**PLANNING ACT 2008
APPLICATION BY HIGHWAYS ENGLAND FOR AN ORDER GRANTING DEVELOPMENT CONSENT FOR THE A303 SPARKFORD TO
ILCHESTER DUALLING**

A303 Sparkford to Ilchester Dualling Submission for Deadline 4

South Somerset District Council's Comments on the Applicant's Deadline 3 Submission - 9.11 Responses to Local Impact Report, Written Representations and comments on responses to the Examining Authority's Written Questions (REP3-003)

South Somerset District Council's Comments on the Applicant's Deadline 3 Submission - 9.13 Summary of In-combination Effects on Cultural Heritage (REP3-005)

WORK NO.94 - POND 5 (SECTION 5A)

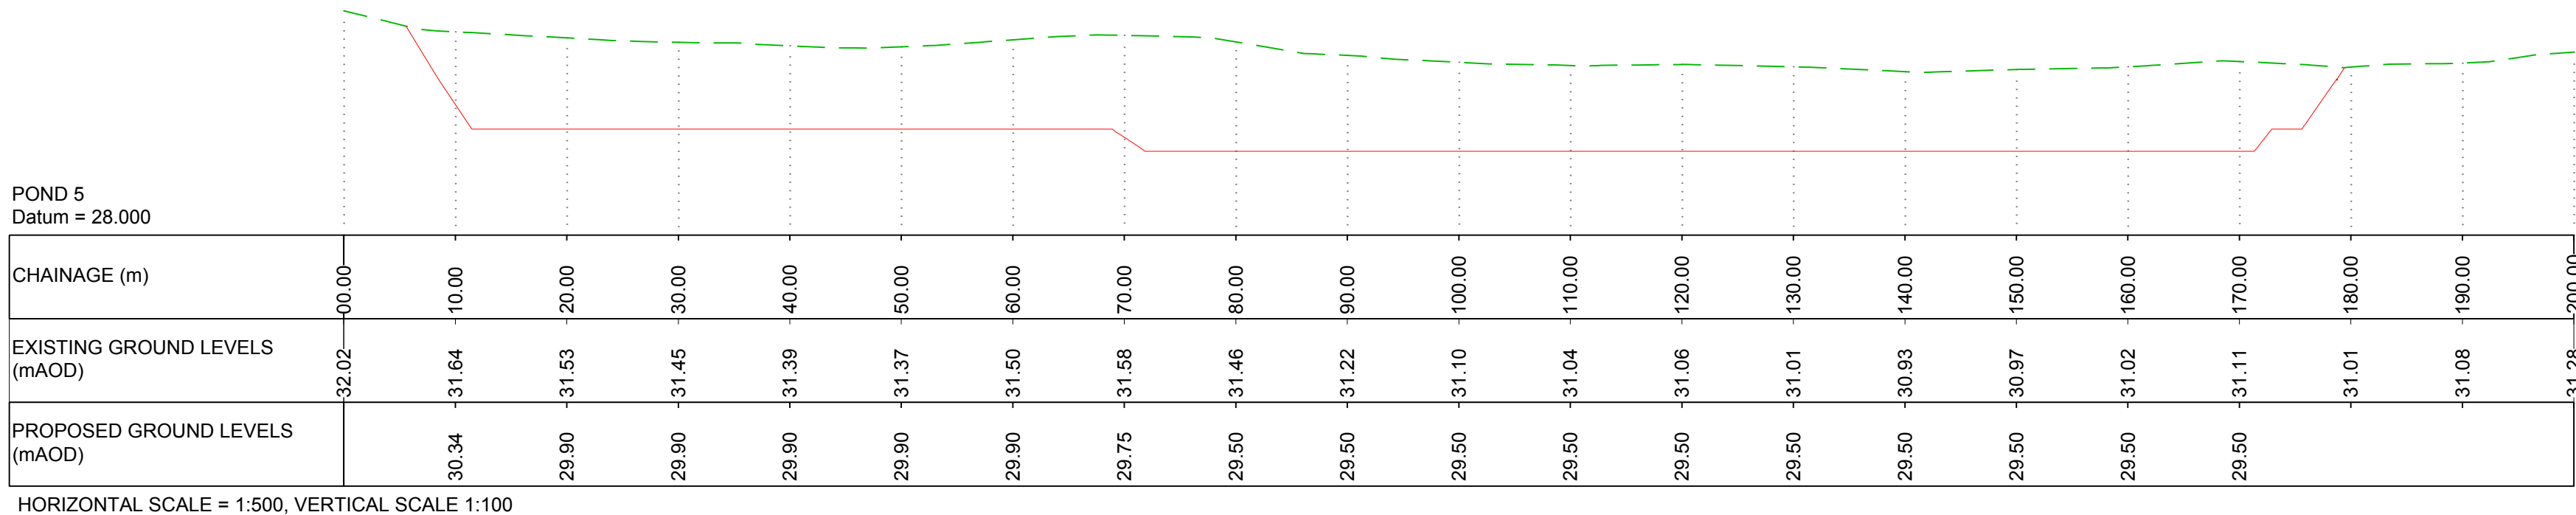
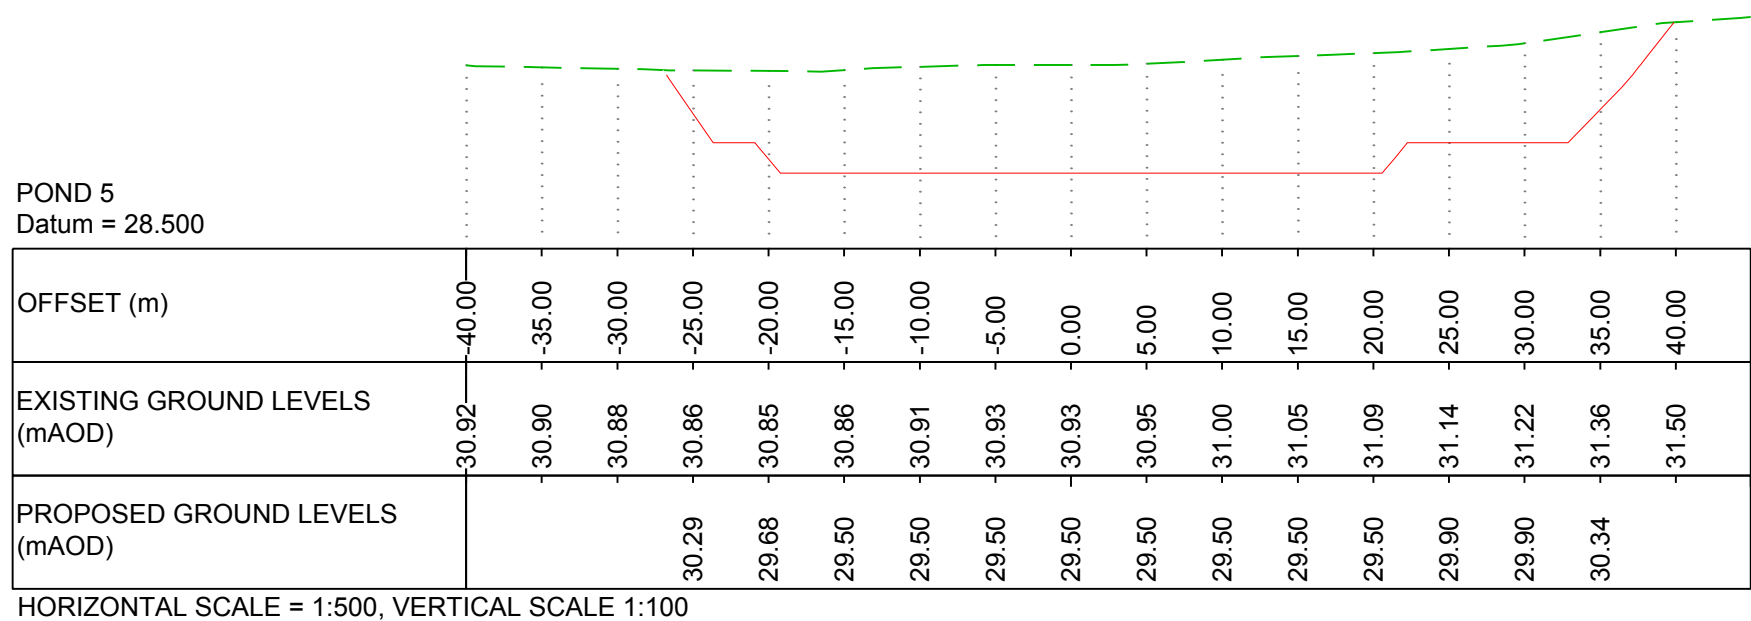
Regarding paragraph 1.7.27, no explanation has been provided as to why Pond 5 cannot be sited outside of the RPG.

The description of the in-combination effects identifies a loss of 10.6 hectares from the RPG. This figure would rise to approximately 13.7 hectares if the fenced area of attenuation Pond 5 and its associated infrastructure were included.
